CITY OF ALBUQUERQUE

**Re: 9000 Alameda Blvd. Grading & Drainage Plan
Engineer's Stamp Dated 5/22/2018
(C20D073)**

Based upon the information provided in the submittal received on 5/23/2018 the above-referenced plan cannot be approved for Grading or Floodplain Development Permit until the following are addressed.

ARROYO  
STA: 10+00.00 TO 12+23.57  
\*-ALL STATIONING BASED UPON PROPOSED CENTERLINE

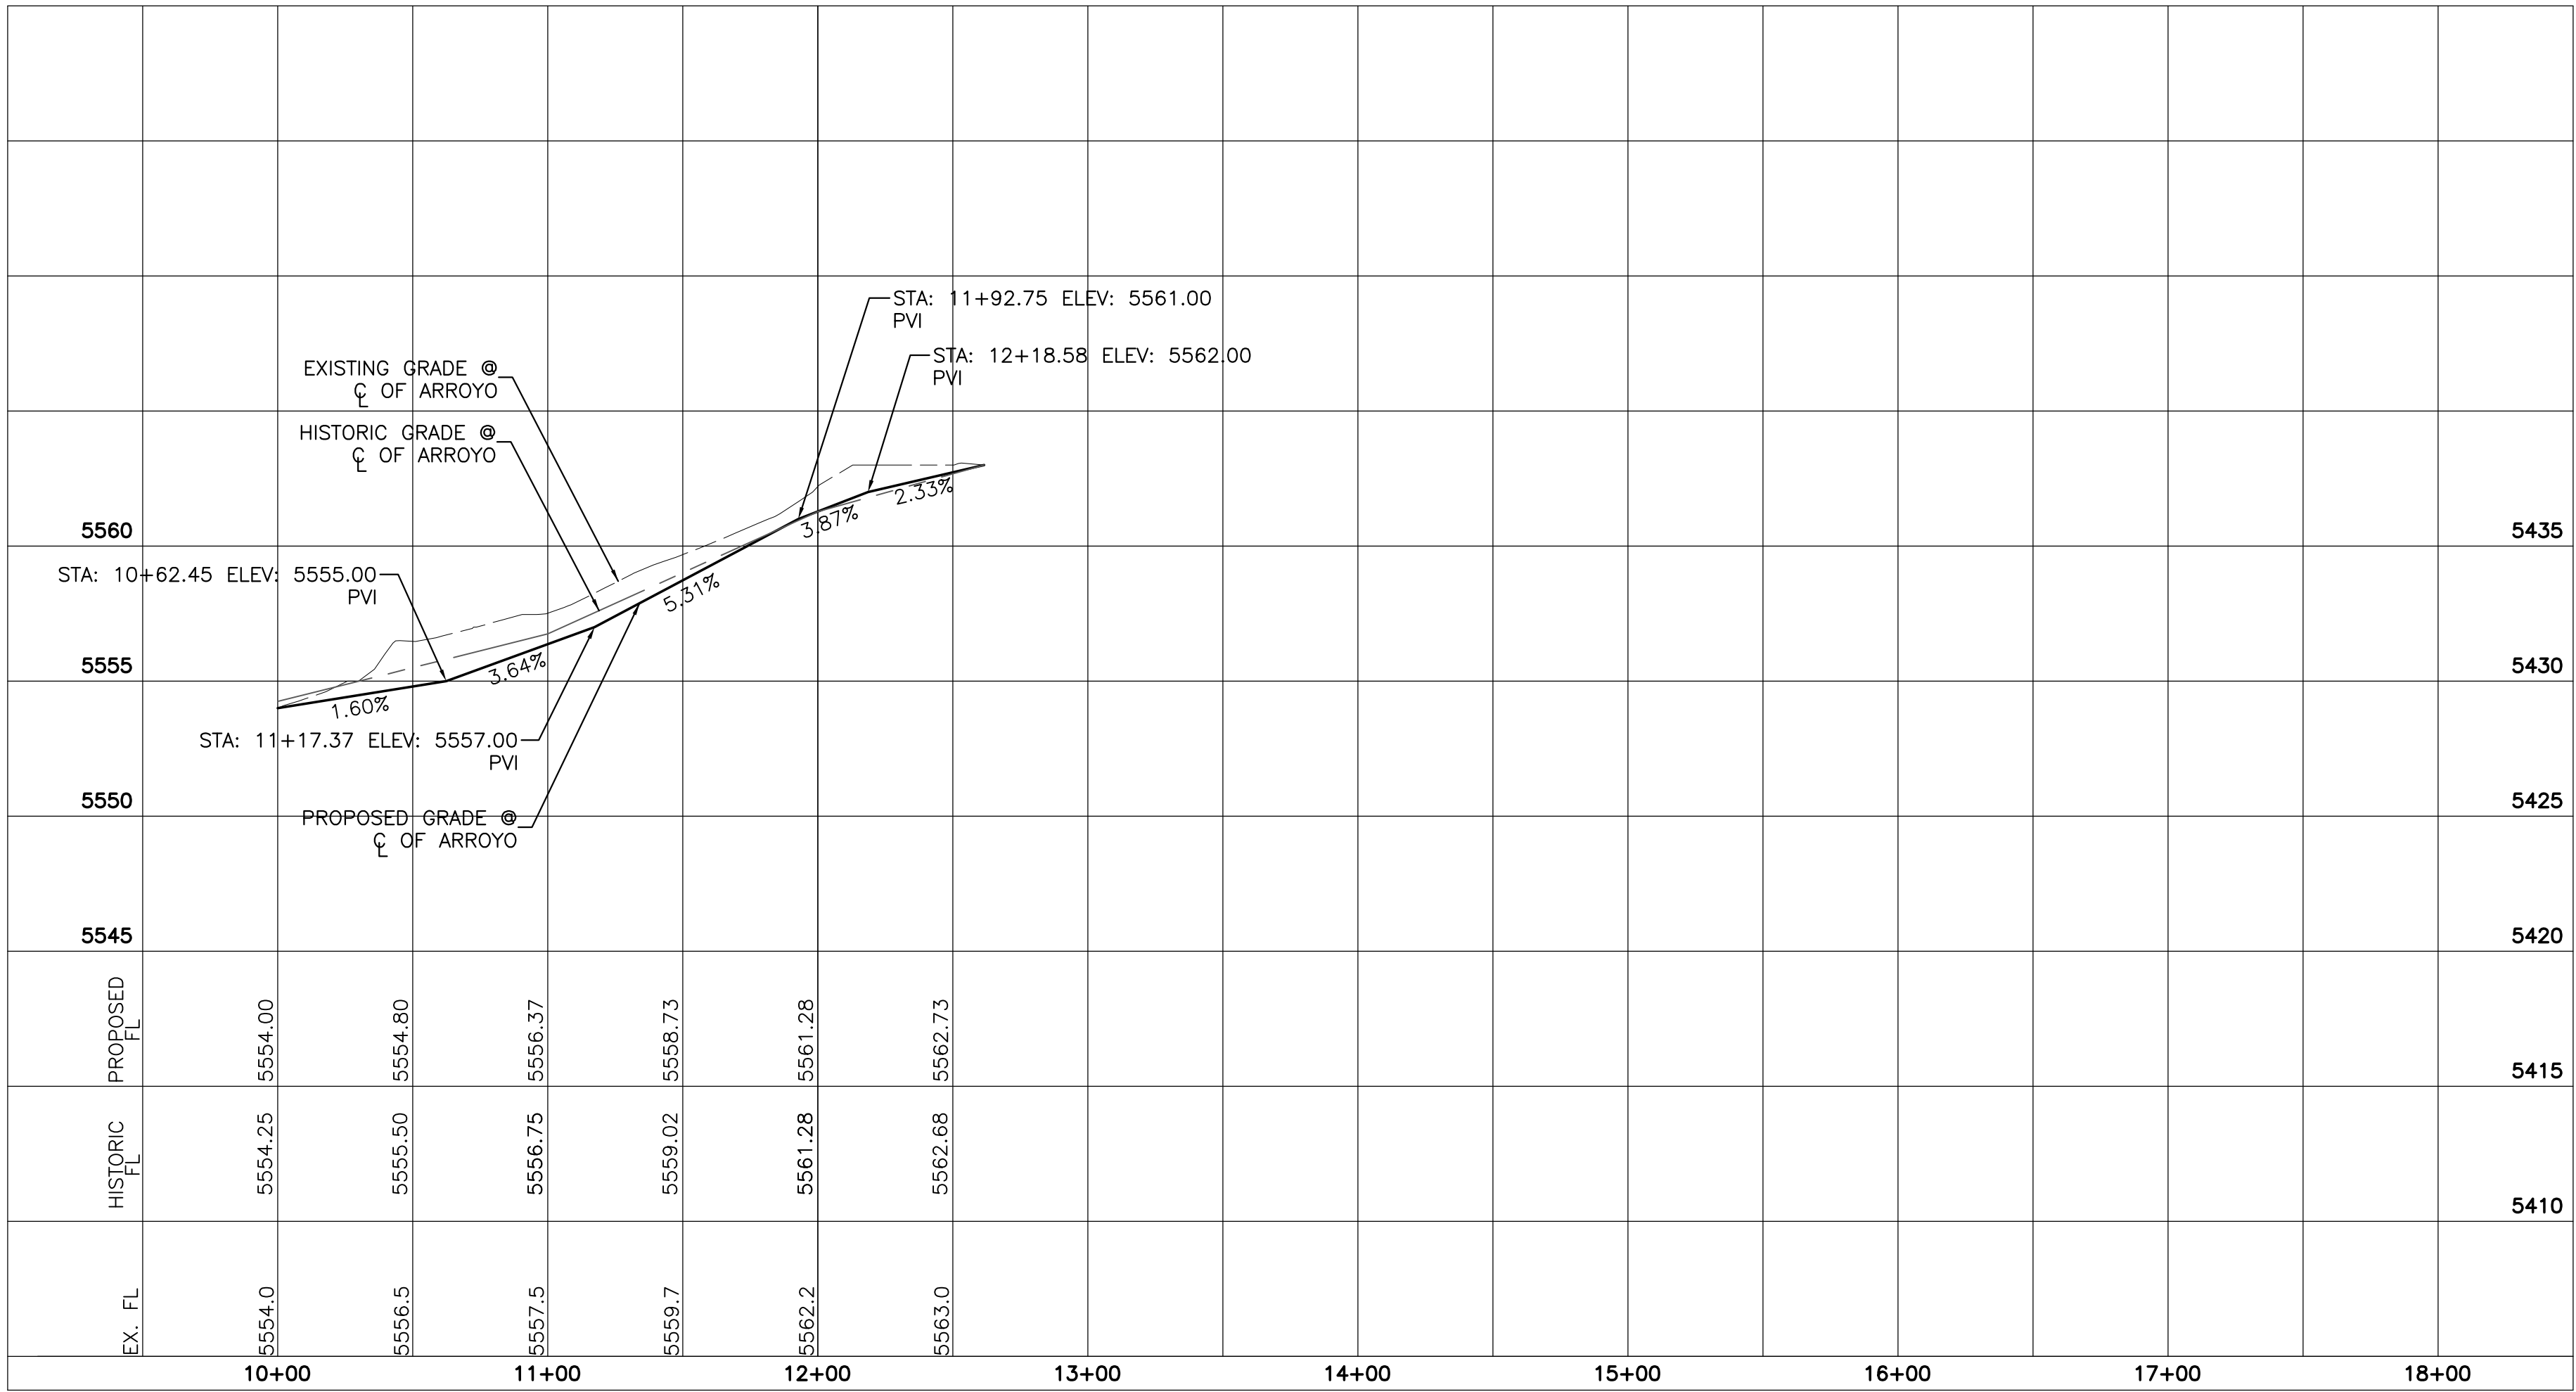
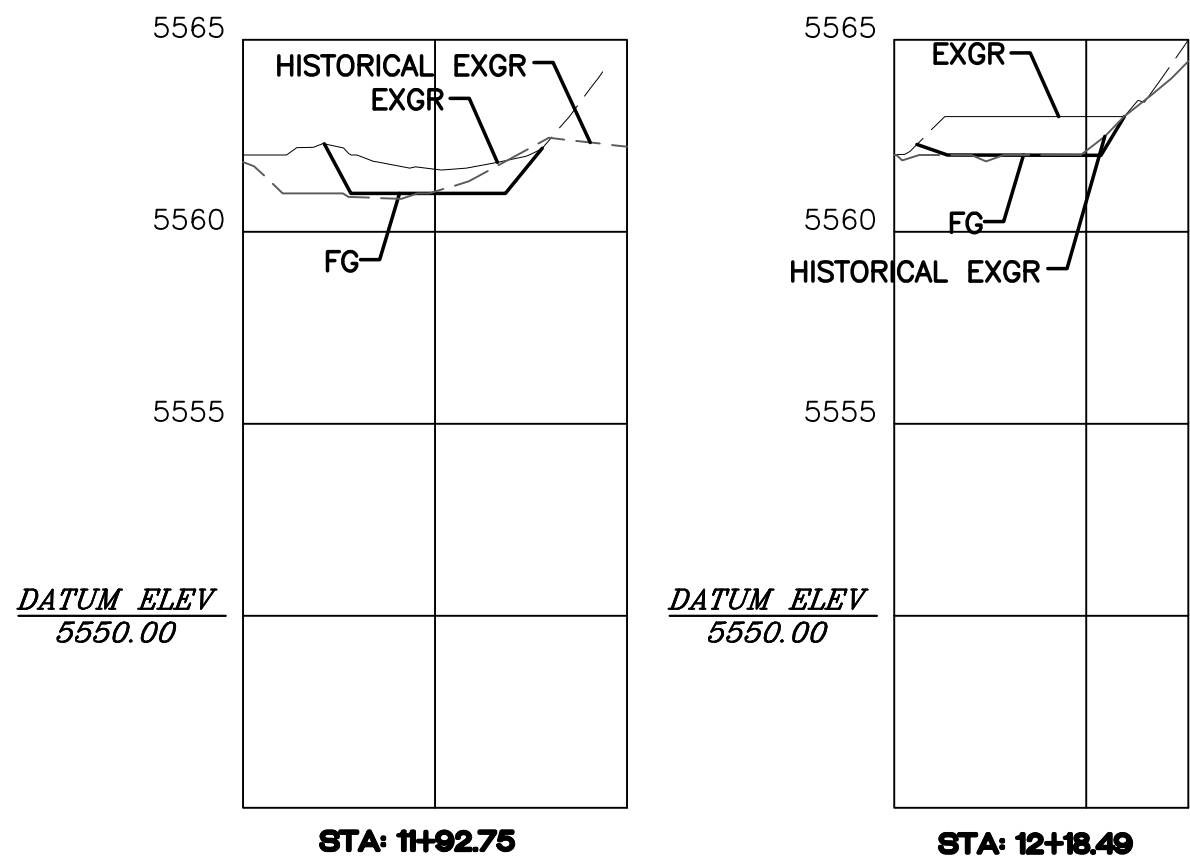
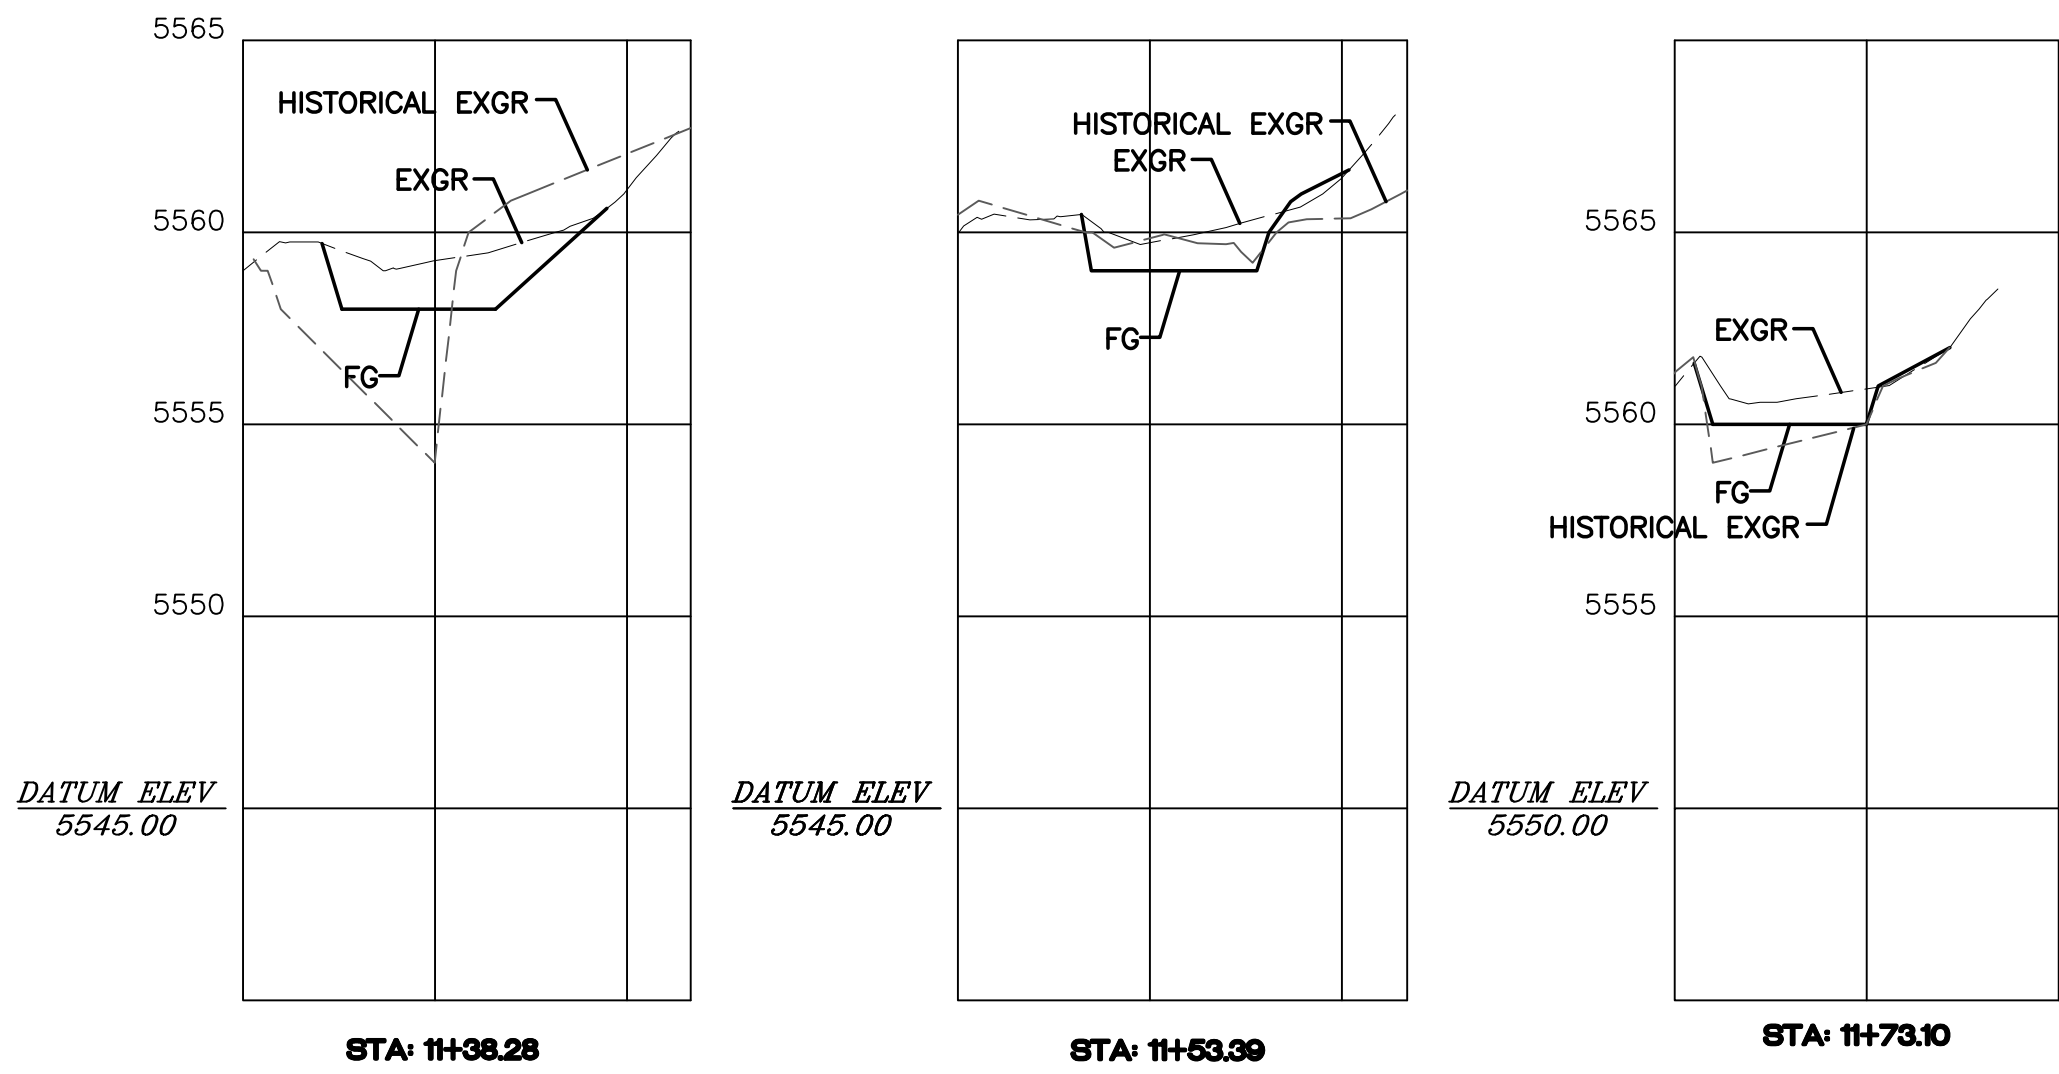
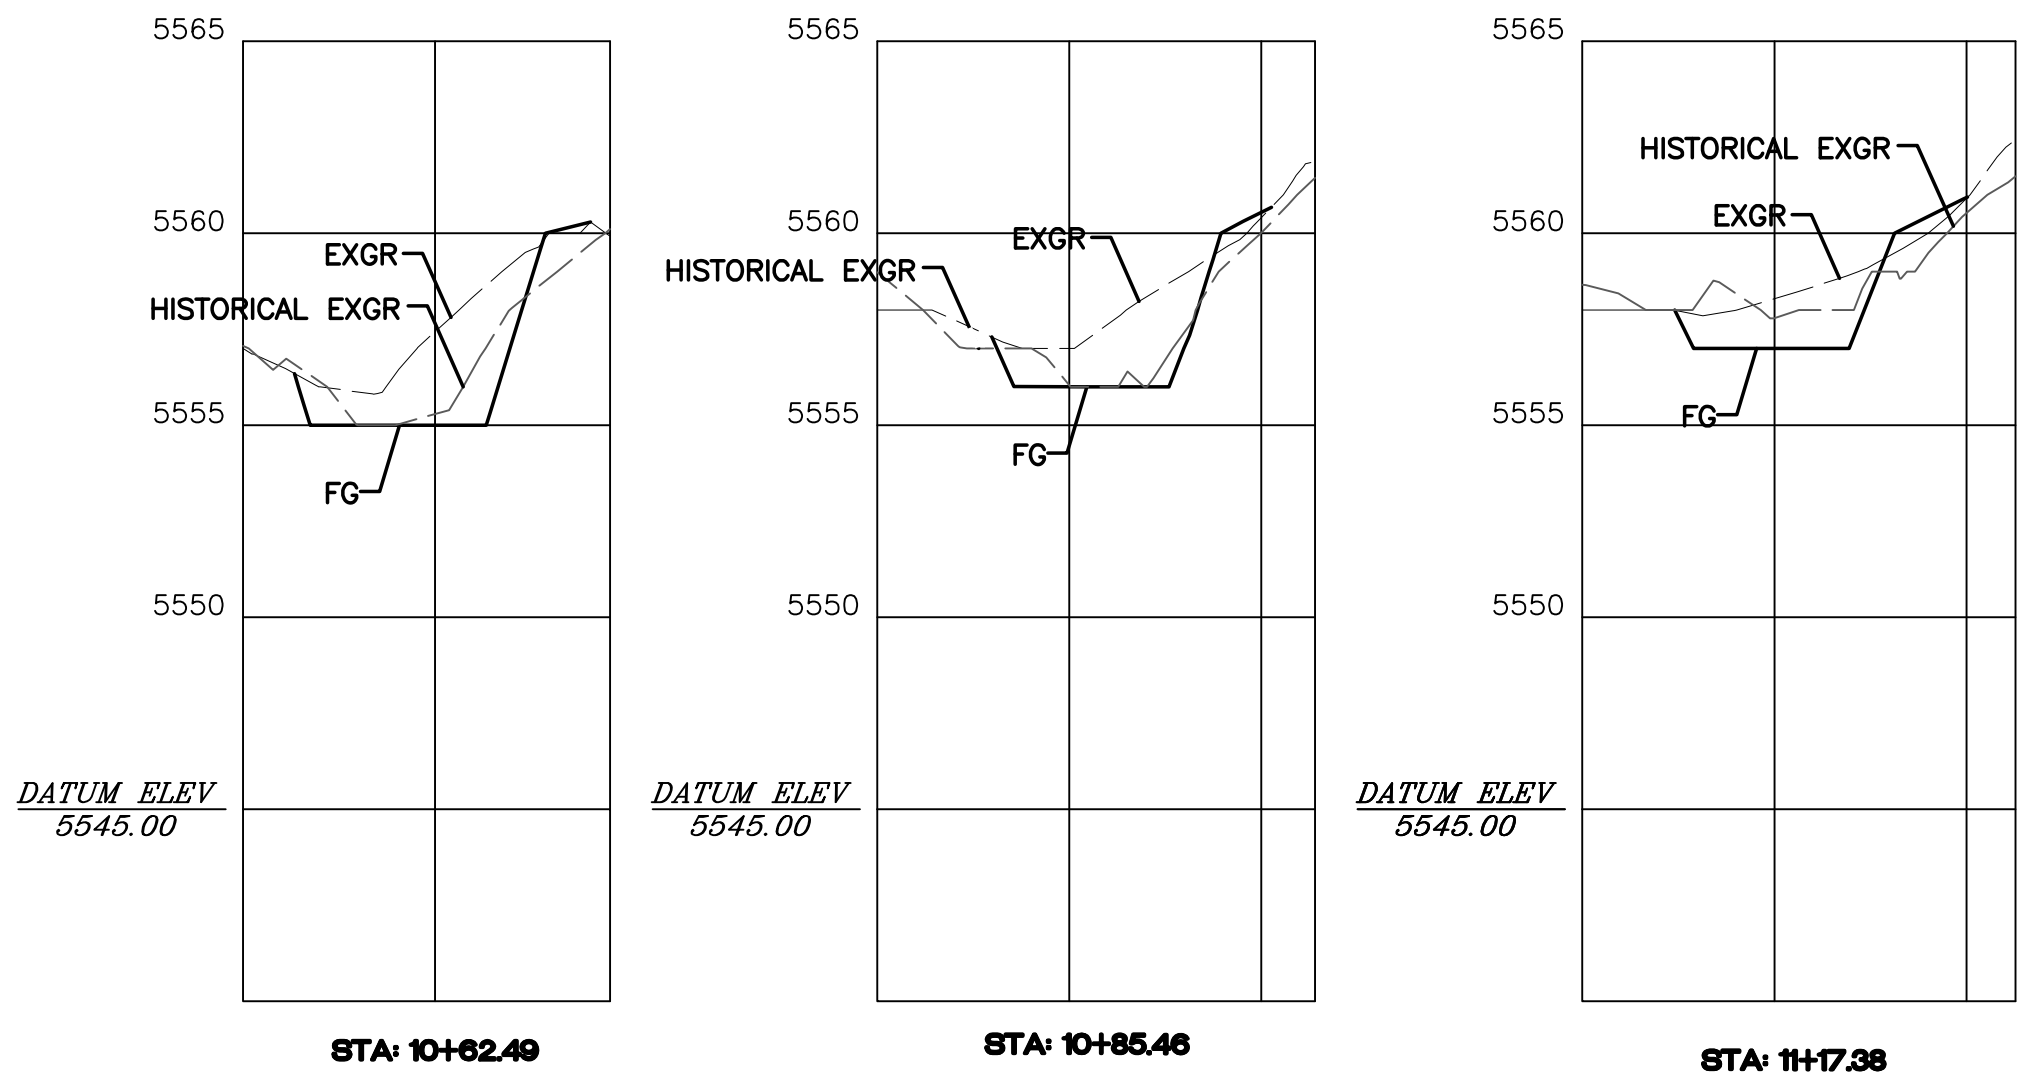
- Written approval of the plan is required from the Corps of Engineers.
- Include PVI station and elevation on the profile of the arroyo.
- Provide the signed and notarized original easement to Madeline Caruthers along with a check for 25\$ payable to Bernalillo County.
- Label the dimension of the bottom width of the trapezoidal channel and maximum 3:1 side slope. Also show the grade that was there before the house was built on the sections.
- Screen the existing house and grading that has already been completed around the house so that it does not look like it is part of the construction.
